Sent: 23 December 2011 09:44  
To: Planning  
Subject: Comments Added: Land adjoining 29 & 30 Greenfields, South Drive, Cuffley

Application ID: S6/2011/2685/FP Mr M Peacock Application Owner: Welwyn & Hatfield Borough Council(Development Control Officer)  
Applicant: Levitt Partnership Ltd  
Location: Land adjoining 29 & 30 Greenfields, South Drive, Cuffley Deadline Date: 13/01/2012 00:00:00  
Description: Erection of two bunaglows  
Comment Added:

Drawing Title  
**SITE PLAN  
BUNGALOW FLOOR & ROOF PLANS**

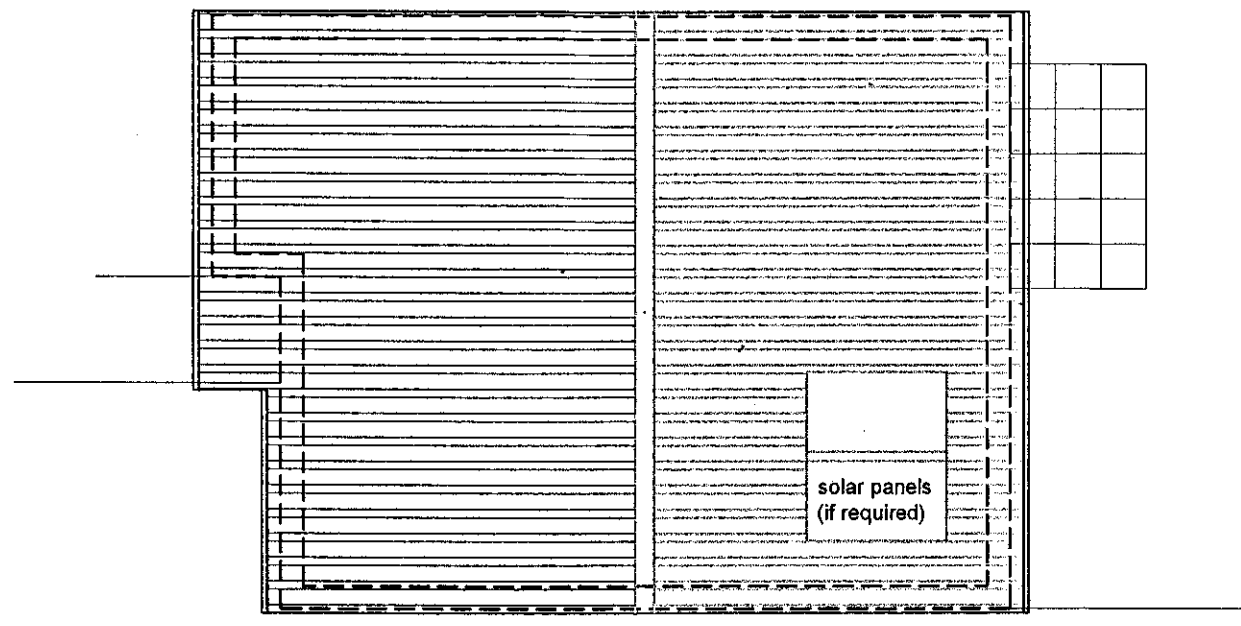
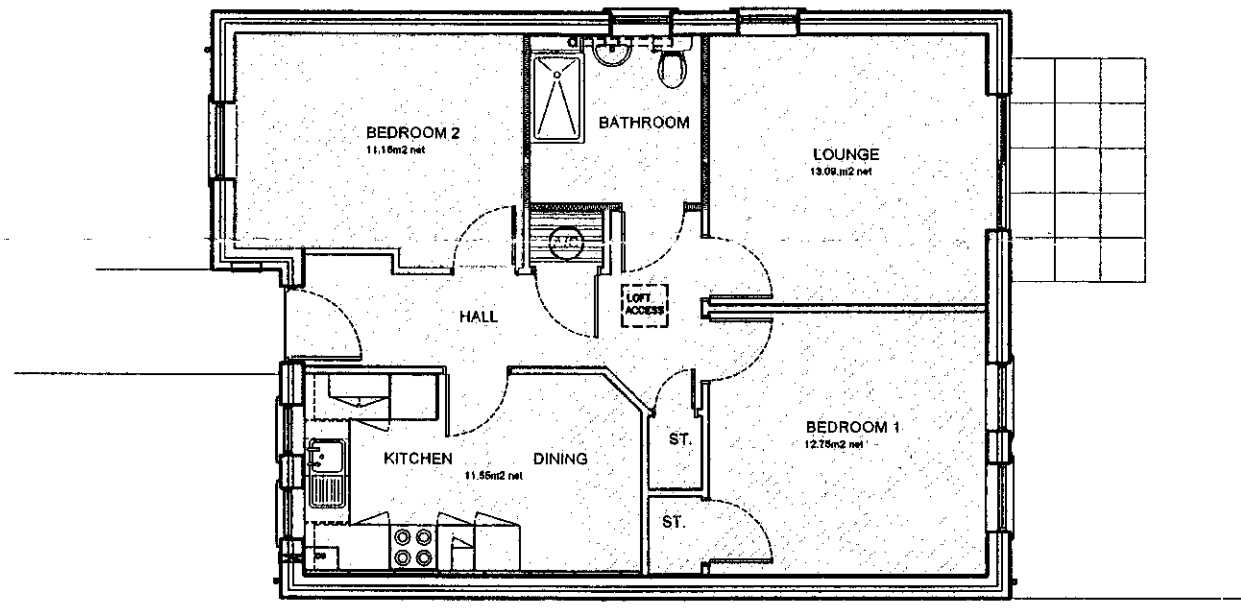
Comment: I note that the storage area for refuse/recycling is based on two wheeled bins, but our service has three wheeled bins, so this would need to be increased in size to be appropriate.
